# **City of Albuquerque**

**RE: MESA VIEW CHURCH PHASE 1 (E-11/D13A)**  
**(4701 Montano Rd NW)**  
**ENGINEERS CERTIFICATION FOR CERTIFICATE OF OCCUPANCY**  
**ENGINEERS STAMP DATED 1/8/2002**  
**ENGINEERS CERTIFICATION DATED 12/1/2002**

**RE: Grading and Drainage Plan for Mesa View Church (E11-D13A) Dated January 8, 2002**

**Re: Grading and Drainage Plan for Mesa View Church (E11/D13A)  
engineer stamp dated 01/08/2001.**

GRADING AND DRAINAGE PLAN

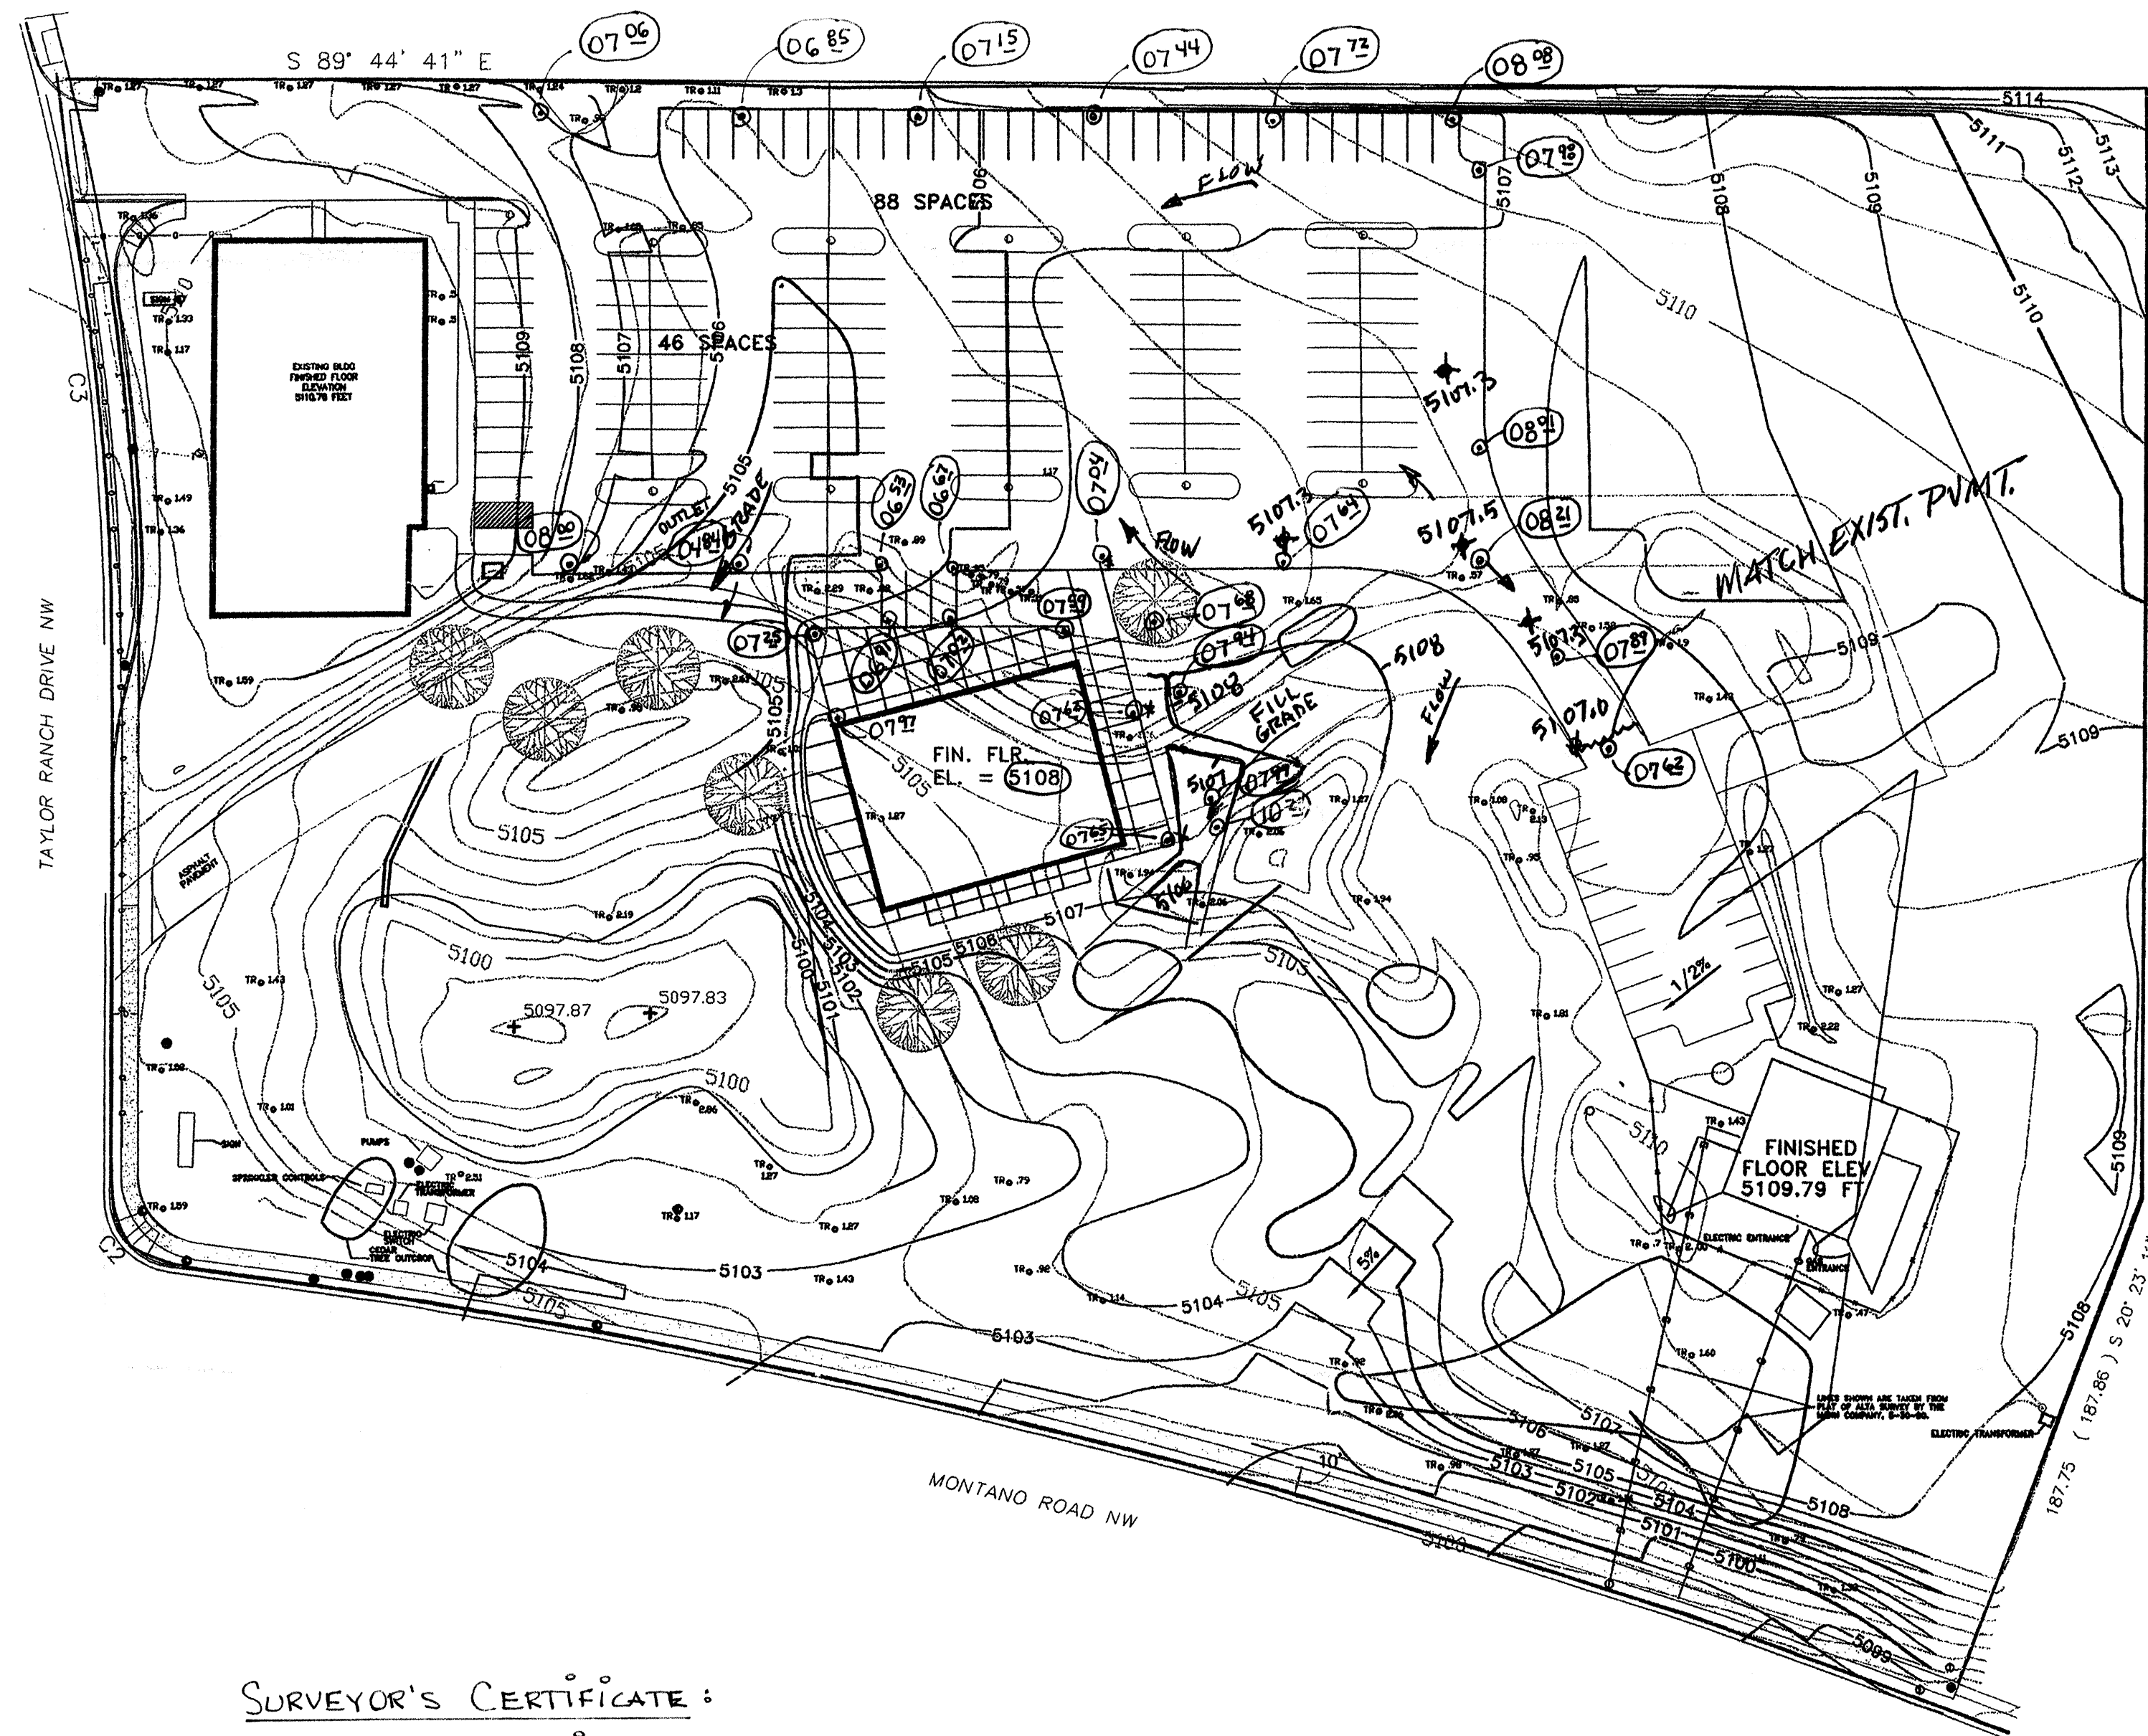
Please Note: In future submittals regarding Engineers Certification, please follow the attached DPM approved format, in lieu of using your standard certification language. This language should be placed directly on the grading and drainage plan.

The above referenced drainage plan is approved for building permit. As per my previous request letter and our conversation there is a CMU wall on the east side of the property. The wall extends along the property line.

1. Install sidewalk culvert and waterblock near the SW corner of parking lot subbasin 2 and provide grass or cobble rock drainage swale to drain parking lot to ponding area. Provide updated ponding volume calculations to reflect this change.
